From: Paul Troop [redacted]
Sent: 29 October 2021 17:06
To: Planning <Planning@Cherwell-DC.gov.uk>
Cc: bicesterbug <george@bicesterbug.org>
Subject: Comments on Planning Application 21/03343/F on behalf of Bicester Bike User's Group
Importance: High

Thank you for offering us the opportunity to comment on the above application. Our comments are related to the proposed cycle storage provision, which appears to consist of 30 covered 'Sheffield' stand type places.

**CYCLE SHELTER DETAIL**

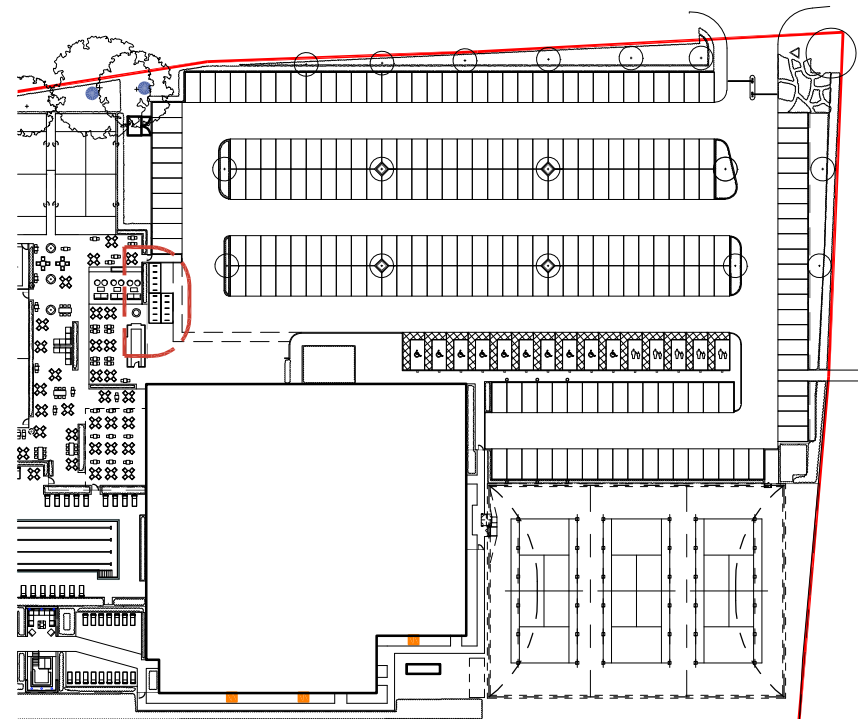
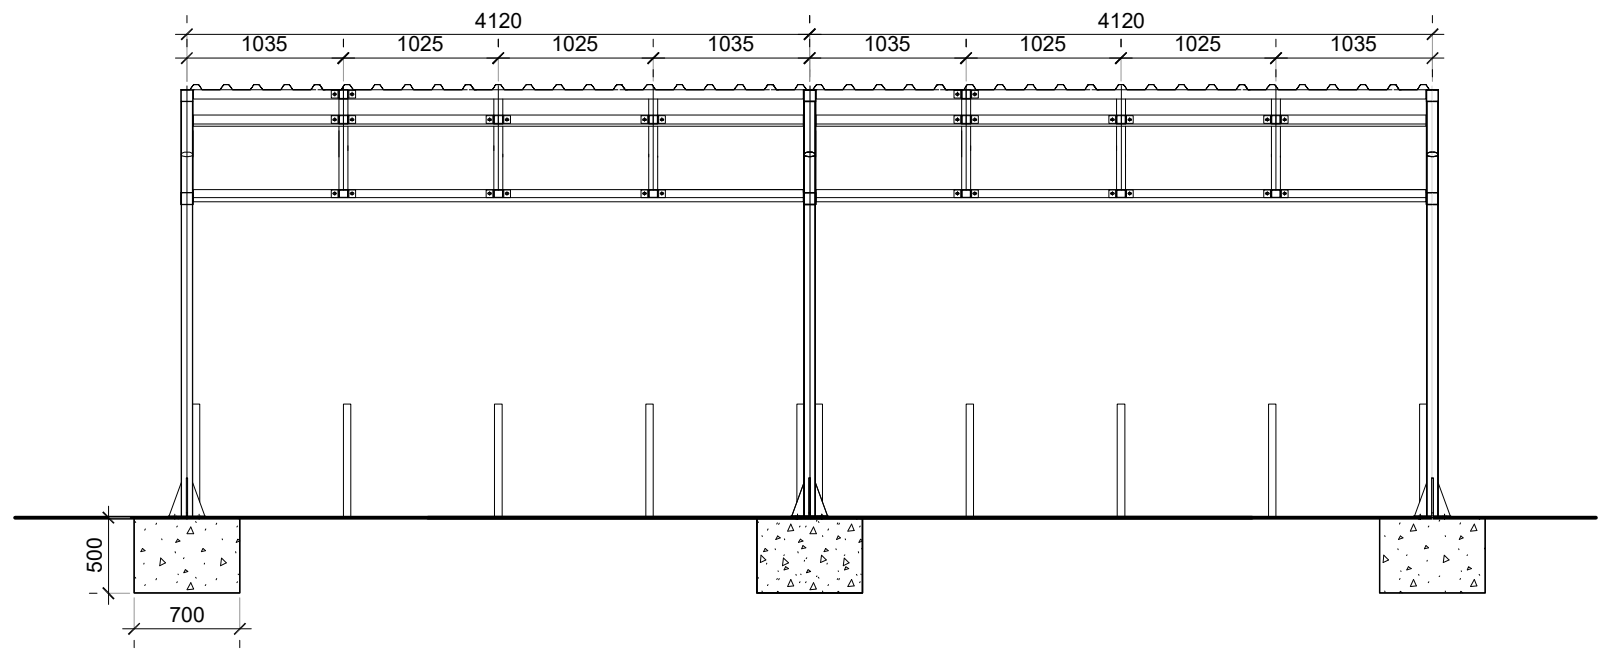
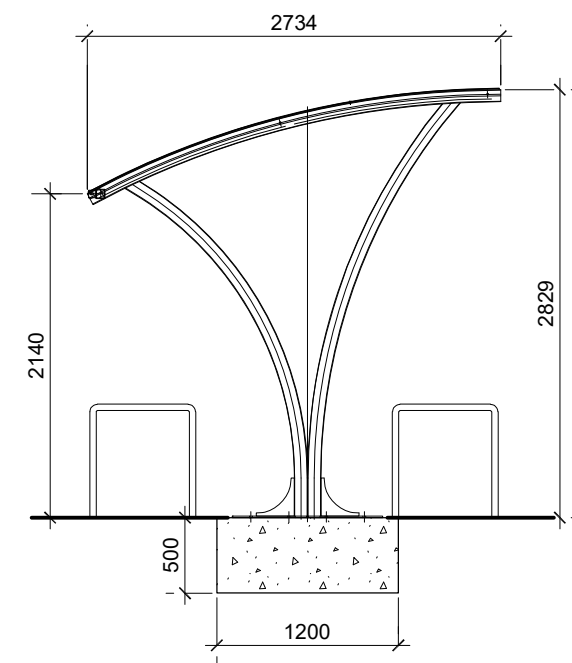
The current guidance in Local Transport Note 1/20 recommends at Table 11-1 that leisure facilities provide:

- Short stay, obvious, easily accessed, and close to the destination of 1 place per 50m2 capacity; and
- Long stay, secure and covered, of 1 per 5 employees

In addition, the provision should consist of at least 5% of the places for non-standard and adapted bicycles for the disabled.

As a result, the current proposed provision does not appear to meet with the guidance. We therefore would object to the application unless it was revised to include:

- Sufficient short stay provision
- Sufficient long stay provision with adequate security; and
- For both, a minimum of 5% provision for non-standard and adapted bicycles.
